Christina Stacey - RE: Permit #364 - Citgo gas station, 1585 Forest Ave.

From: Christina Stacey [mailto:cstacey@portlandmaine.gov]
Sent: Thursday, February 25, 2016 12:38 PM
To: Kevin Moore
Subject: Permit #364 - Citgo gas station, 1585 Forest Ave.

EXISTING
SIGN

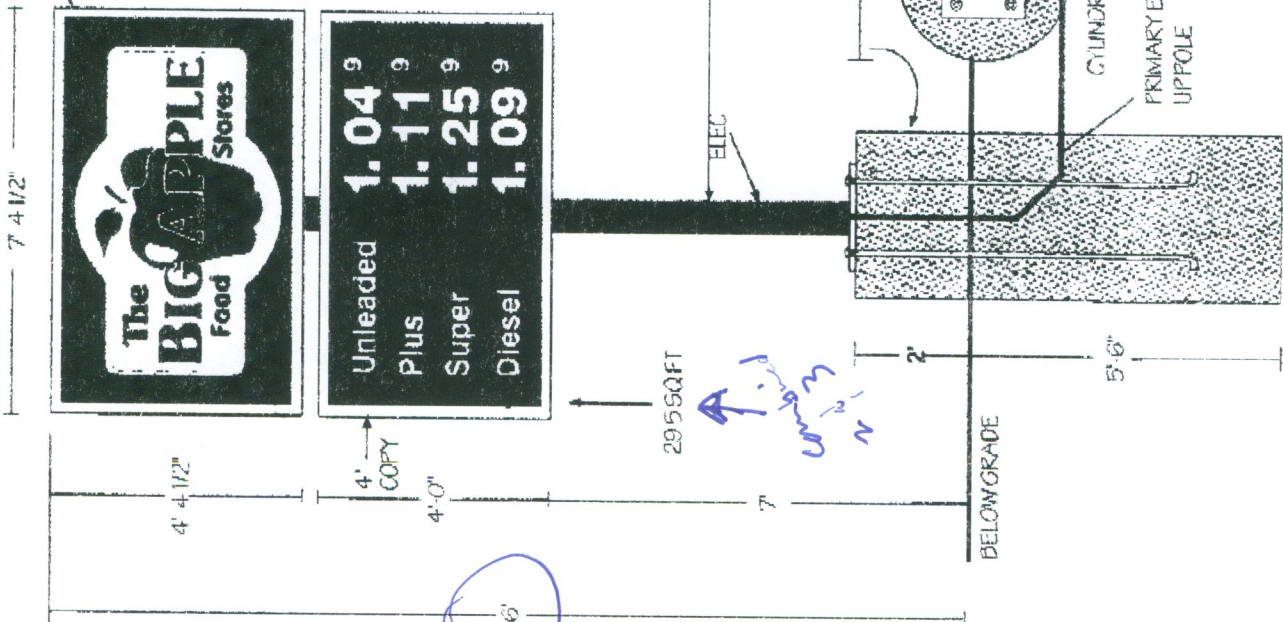
The other problem is in regards to the free-standing sign. There was no plot plan submitted with the application, but based on aerial photos it looks like the edge of the sign along Forest Avenue is less than the 5' setback from the property line that we require. The sign is an existing grandfathered sign, but my concern is that the new sign appears to be about a foot wider than the old sign, which will make it even closer to Forest Ave. Can the sign or post be redesigned to ensure that the edge of the sign does not go any closer to Forest Ave.?

I am forwarding you the original layout, we changed it thinking the visibility for the Citgo would be better on the road side. We are okay with this layout. On the sign issue, I will install an offset pole, if needed, so the sign will not be any closer to Forest Ave then it is now. Anything else I can help with, please feel free to contact me.
